From: Amanda Scholes on behalf of Planning.Responses
Sent: 02 November 2017 08:54
To: Planning Scanning
Subject: FW: Planning Consultation on: LU/249/17/PL

Comment from Greenspace

Registered: 8th August
2017
Site Address: Directors Cottage Toddington Lane Littlehampton
BN17 7PP
Grid Reference: 503295 103948
Description of Works: Demolition of the existing bungalow &
redevelopment of the site with 5 No. detached
houses. This application is a Departure from the
Development Plan

Drawing: **LOCATION, STREET SCENE & EXTERNALS**

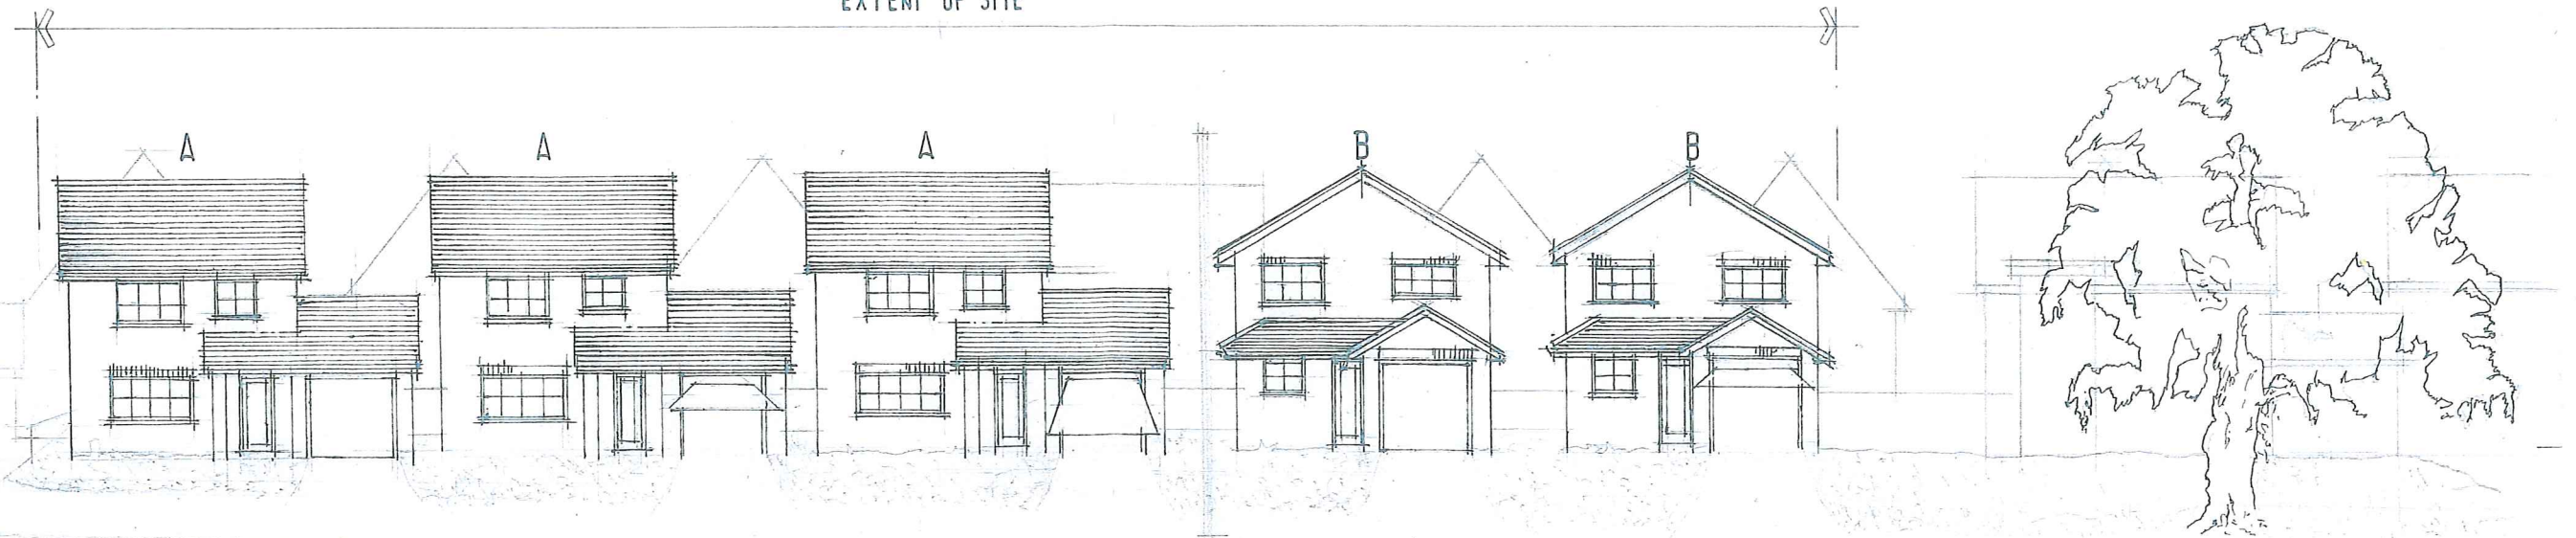
Greening in the form of landscaping of any kind would be welcome to any potential development, which does not appear to have been detailed. Whilst we would not be looking for any open space or play provision for this proposal a landscape plan to show planting proposals with planting mix and size at time of planting would be recommended for submission.

We would recommend that the landscape detail is submitted for approval, but would have no objection to the proposals as shown.
